**From:** [Aaron Webster](#)  
**To:** [Jeremiah Cromie](#)  
**Cc:** [Adam Osbekoff](#); [Steven Moses](#)  
**Subject:** RE: SP-23-00002 Mills-2 - Notice of Application  
**Date:** Thursday, May 18, 2023 1:41:12 PM

RE: SP-23-00002- Mills-2

**TO:** All Staff  
**FROM:** Public Works Plan Review Team  
**DATE:** June 5<sup>th</sup>, 2023  
**SUBJECT:** SP-23-00002 Mills-2

MILLS-2 SHORT PLAT

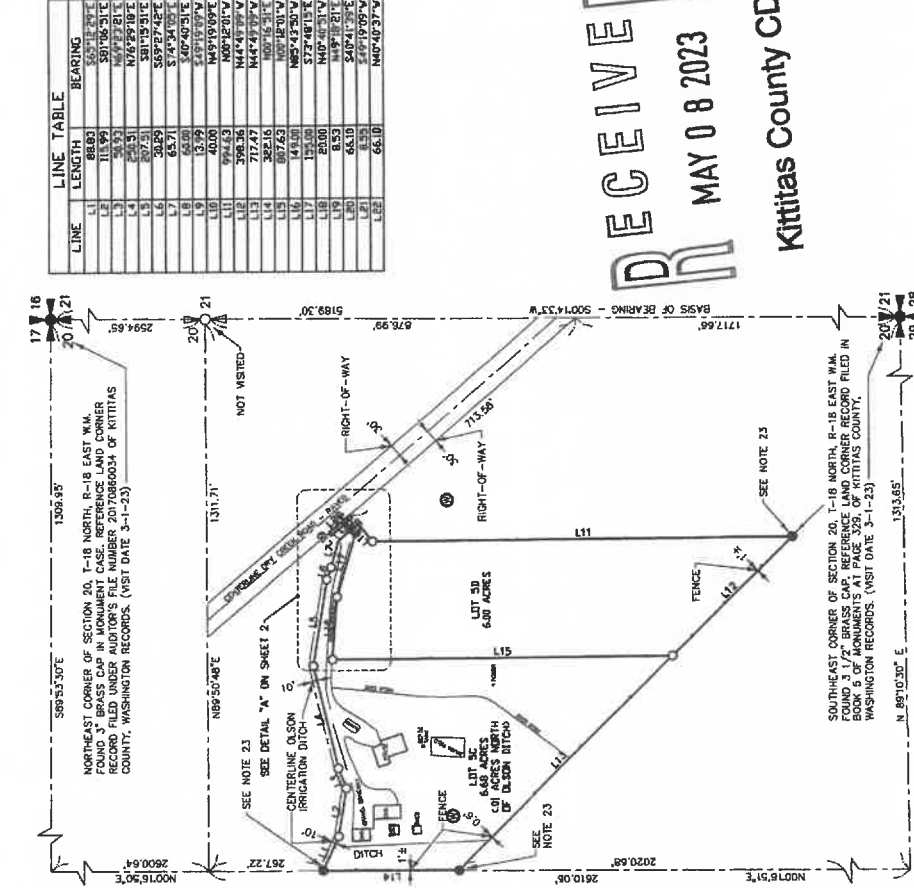
<b>SURVEY</b>	<p>The following elements will need to be addressed prior to final:</p> <ol style="list-style-type: none"> <li>1. Legibility of small text for the topo features on Lot 5C, Sheet 1. Please check minimum text height of 0.08".</li> <li>2. Legibility of line Tag labels on sheet 1 due to crossing linework and staged Tag Labels.</li> <li>3. Please identify Dry Creek Road as "County Right of Way".</li> <li>4. Legibility of "Gravel Driveway" text on Sheet 2 due to hatching.</li> <li>5. Please clearly identify the Hatched area on Sheet 2 as the Access Easement, and identify it as "Herein Created" or "Created by separate document". (JT)</li> </ol>
<b>TRANSPORTATION CONCURRENCY</b>	<p>No transportation concurrency application is required at this time. (KH)</p>
<b>FLOOD</b>	<p>Parcel # 960738 is not mapped within the special flood hazard area (100-year floodplain).</p>
<b>WATER MITIGATION/ METERING</b>	<p>For the proposed short plat, the applicant must provide legal water availability for all new uses on the proposed lots of this project, which can be provided through mitigation certificates. Prior to final plat approval and recording, the following conditions shall be met:</p> <p>In accordance with KCC Chapter 13.35.027, the applicant shall provide one of the following documents before final plat approval:</p> <ol style="list-style-type: none"> <li>1. A letter from a water purveyor stating that the purveyor has adequate water rights and will provide the necessary water for the new use;</li> <li>2. An adequate water right for the proposed new use; or</li> <li>3. A certificate of water budget neutrality from the Department of Ecology or other adequate interest in water rights from a water bank.</li> </ol> <p>All applicants for land divisions shall also submit information on "proximate parcels" held in "common ownership" as those terms are defined in WAC 173-539A-030 and otherwise demonstrate how the proposed new use will not violate RCW 90.44.050 as currently existing or hereafter amended.</p> <p>Failure to obtain mitigation before commencement of an activity requiring mitigation shall be a code violation subject to enforcement under Title 18 KCC.</p> <p><b>Final Plat Notes</b></p> <p>The following notes shall be placed on the face of the plat:</p> <p>C-1 "Metering is required for all new uses of domestic water for residential well connections and usage must be recorded in a manner consistent with Kittitas County Code Chapter 13.35.027 and Ecology regulations."</p>
